Recommendation Report for Planning Permission for Works or Extension to a Dwelling**REF NO:** R/168/14/HH**LOCATION:** 7 Cross Road
Rustington**PROPOSAL:** Single and two storey extensions (resubmission following R/20/14/)**SITE AND SURROUNDINGS****DESCRIPTION OF APPLICATION**

**Drg No:** 1279/14/P/01

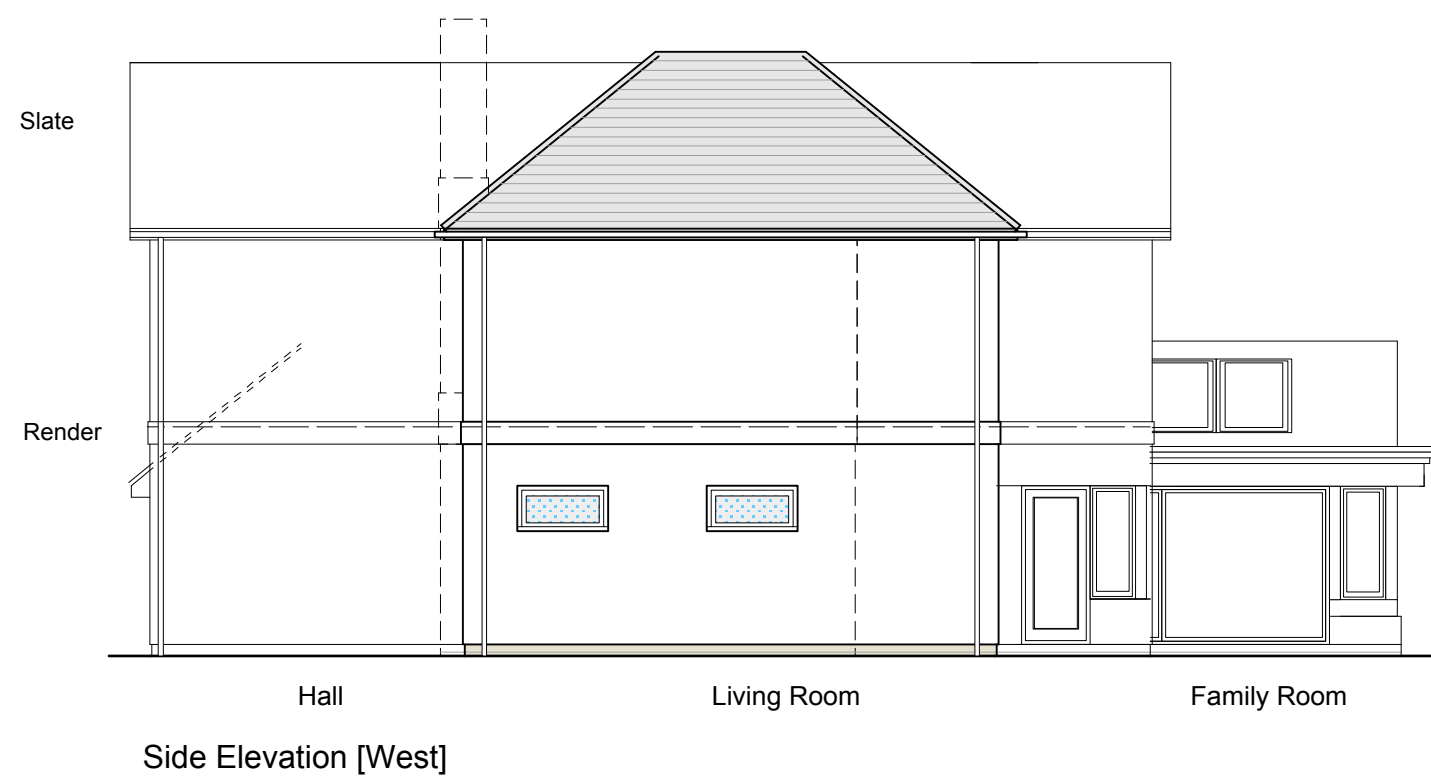
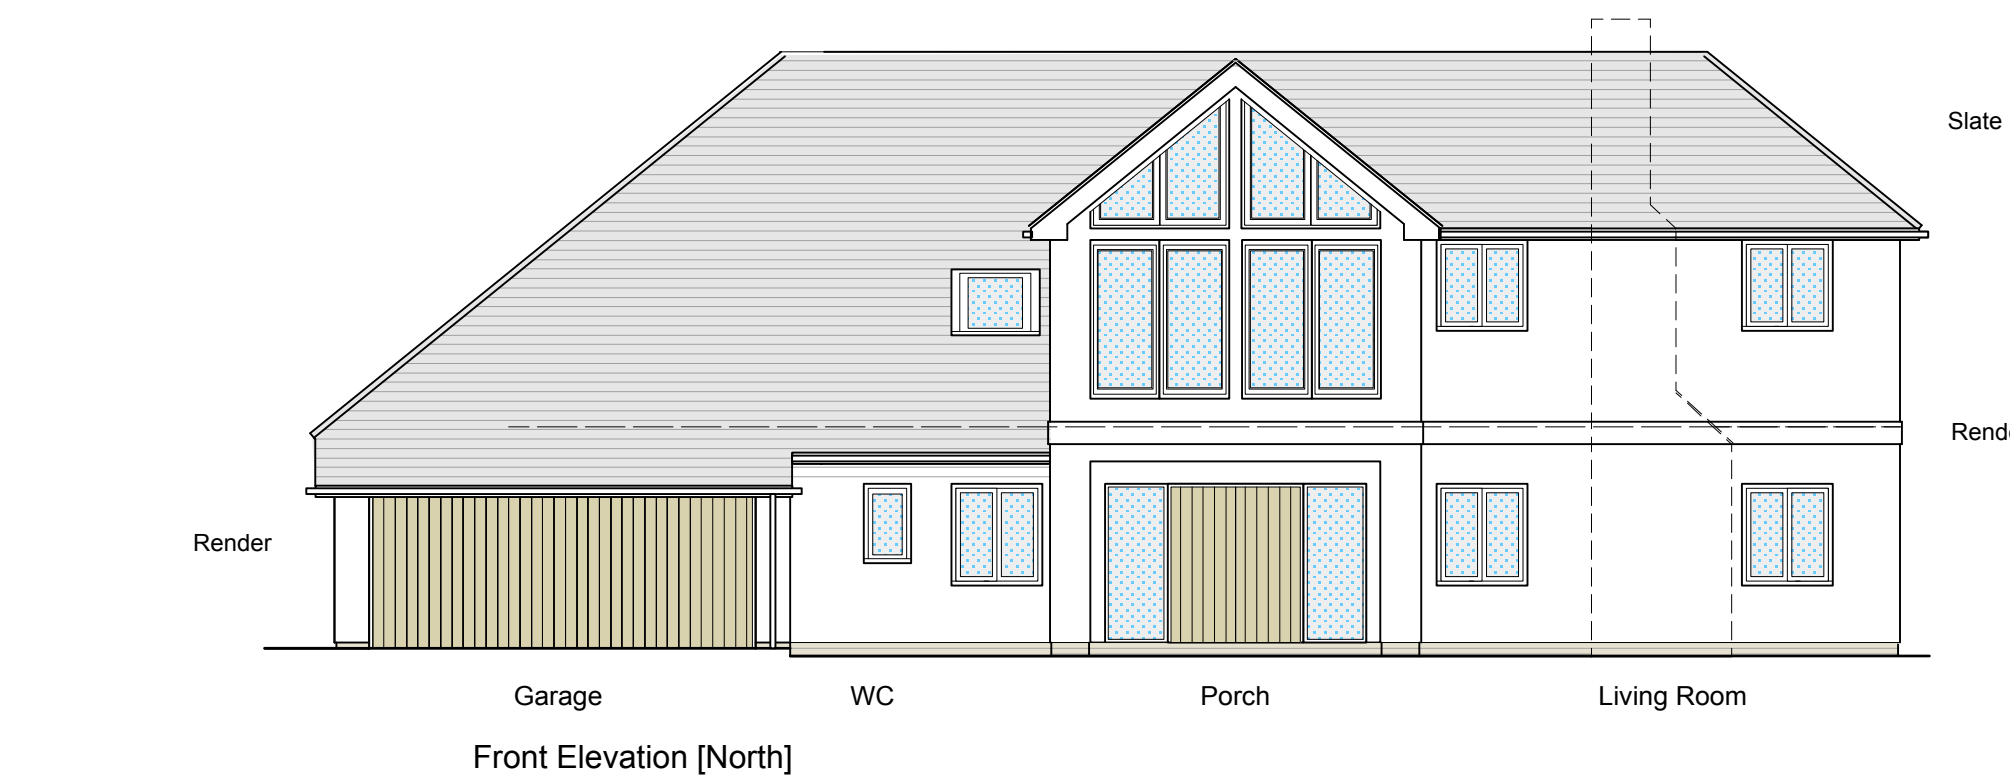
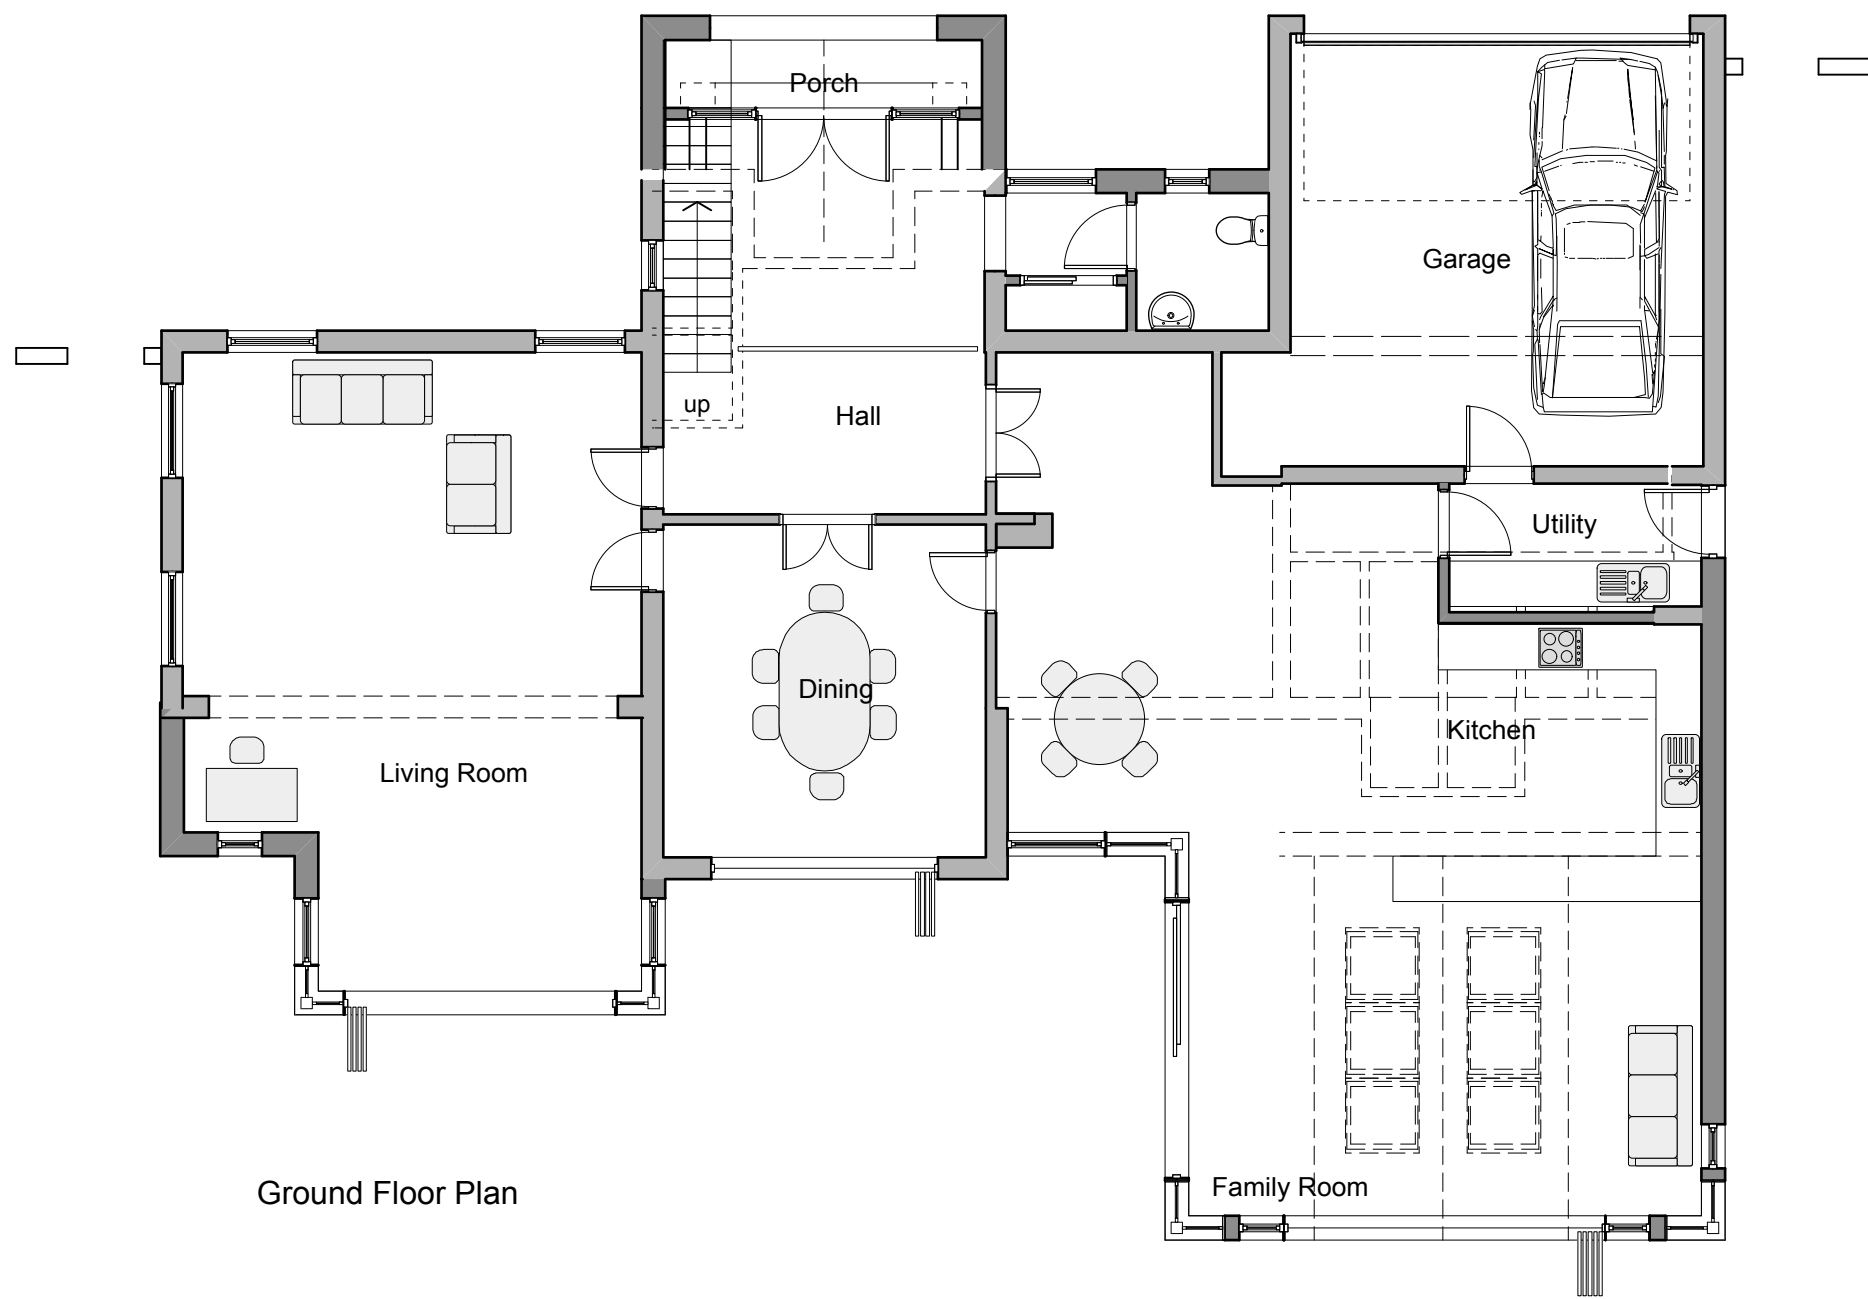
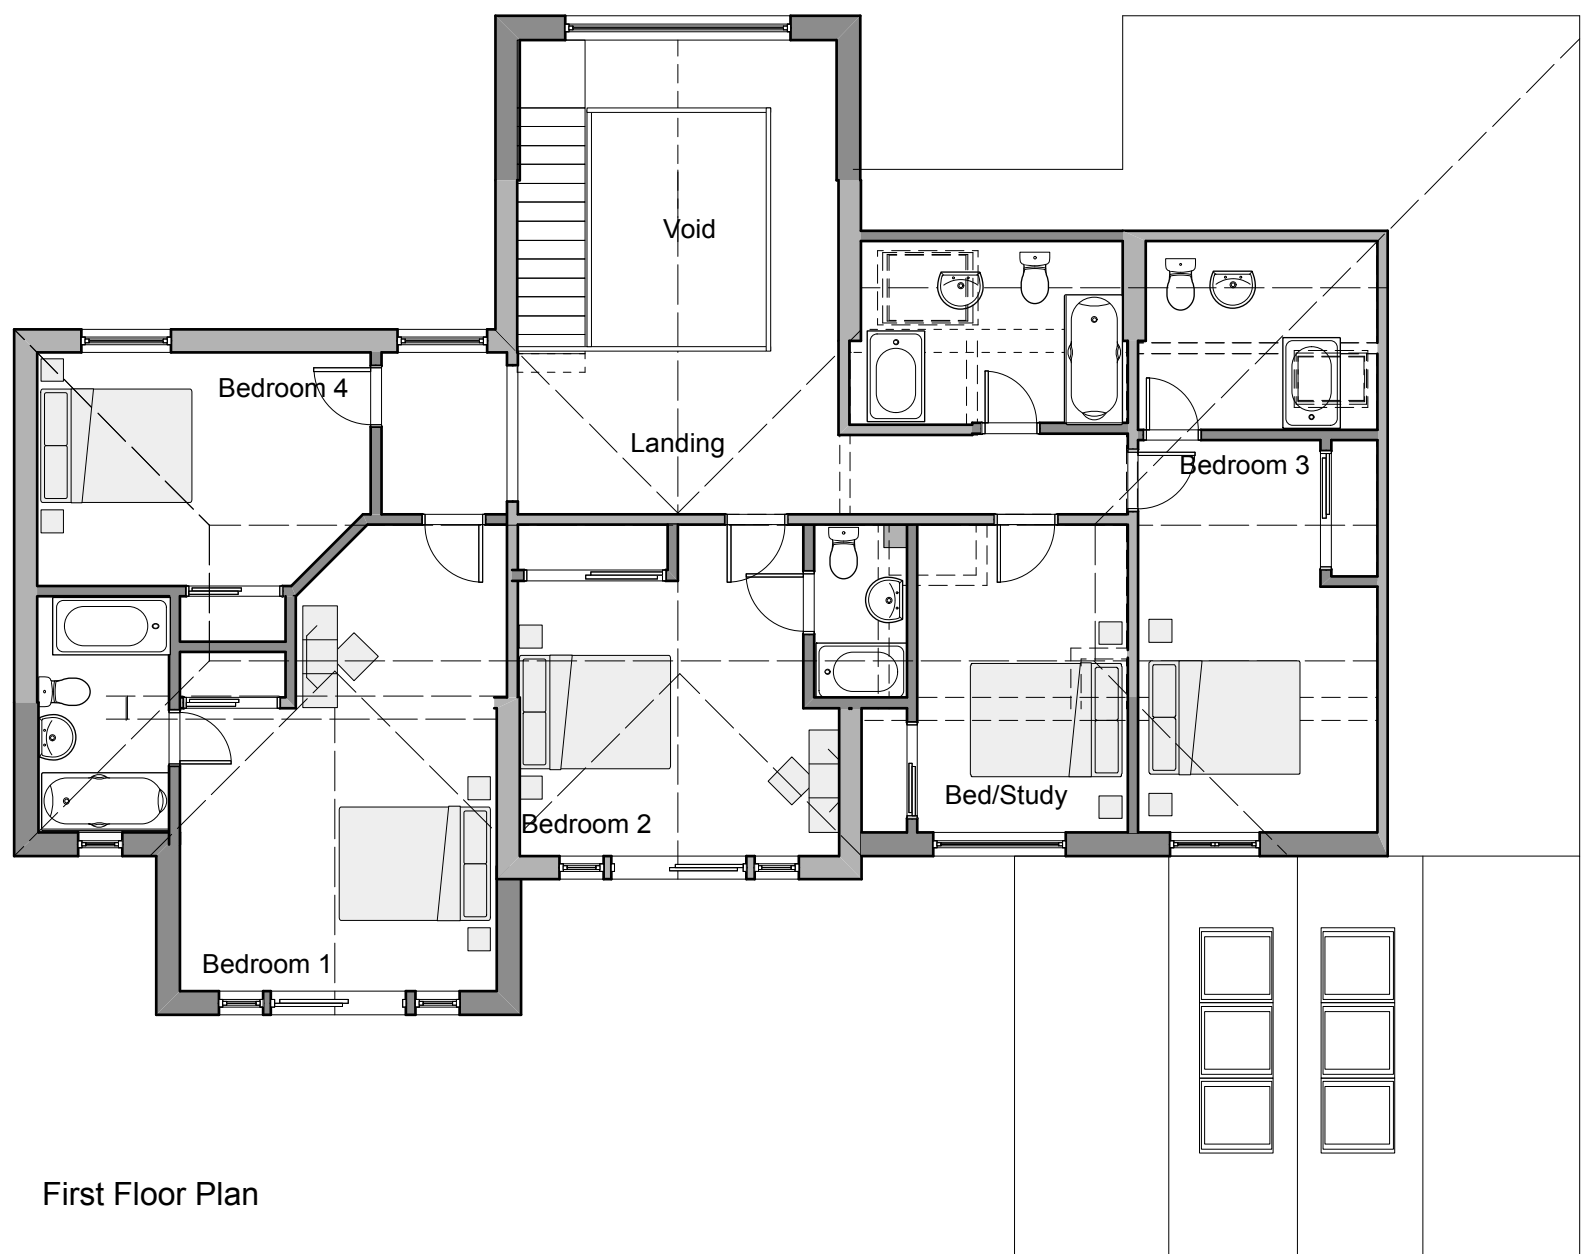
One letter of objection - the plan shows a freefall outside the full length windows of bedrooms 1 and 2. It is assumed there would be safety bars in front, but should these become balconies they would look directly into the large West facing complex of neighbour's main living area and adjoining patio areas. It is requested a condition is imposed preventing the building of such balconies. Any overlooking would be totally unacceptable. The windows in the roof of the extension forming the family room are forward of and immediately below neighbour's window and are potentially the source of disturbing light and noise at night. To reduce this a condition requiring non opening and opaque glazing on the east side is requested. The bathroom window in bedroom 3 facing east would look directly into neighbour's west facing windows. Could this window be relocated?

Any balcony would require the submission of an application for planning permission which would be considered on its own merits. The application can only be considered in relation to what is proposed and it would not be reasonable to impose a condition preventing a structure that would require permission in its own right. The east side of the ground floor extension is mainly brickwork and only the central portion of the roof is glazed. It is not considered that light spill or noise from the family room would adversely affect the residential amenities of neighbouring properties. The levels would not exceed those usually generated by a family home. The proposal as submitted would not result in any materially adverse direct overlooking of the adjoining dwelling. The roof light in the east roof slope would serve a bathroom and would be high level. It is not therefore considered that it would result in materially adverse overlooking or loss of privacy to the adjoining property 5 Cross Road. A condition is imposed relating to obscure glazing, but it is considered that it would be unreasonable to require it to be non-opening given the use of the room and the position and obscure glazing to windows on the side elevation of the adjacent property.

The dwelling is located on a residential road which is characterised by detached dwellings of individual and varying design, but there is a uniformity to their height and distance from the front boundary. In addition most of these dwellings are located with a gap of a minimum of 1 metre to one of the side boundaries and a greater distance to the other. Nos 5 and 3 are characterised by the provision of dormer windows at first floor level which result in a chalet style appearance to the properties and low eaves heights to the main roof. Therefore whilst these dwellings are located close to site boundaries they appear to retain a separation between them and their site boundaries and do not dominate their plots. The application is a re-submission of an earlier refusal which eroded this character. The current proposal retains the gap to the boundary and the front extensions leave a characteristic space to the front boundary and replicate the first floor glazing in other recently approved development in Cross Road.

It is not considered that the proposed extensions would materially harm the residential amenities of adjoining residential properties given the position of the extensions and first floor windows. The application is therefore recommended for approval subject to the following conditions

- 4 The window in the east elevation of the roof shall at all times be glazed with obscured glass.

- 5 No windows (other than those shown on the plans hereby approved) shall be constructed at first floor level or in the roof in the east elevation of the extension hereby permitted which adjoins the side boundary with 5 Cross Road without the prior permission of the Local Planning Authority on an application in that behalf.
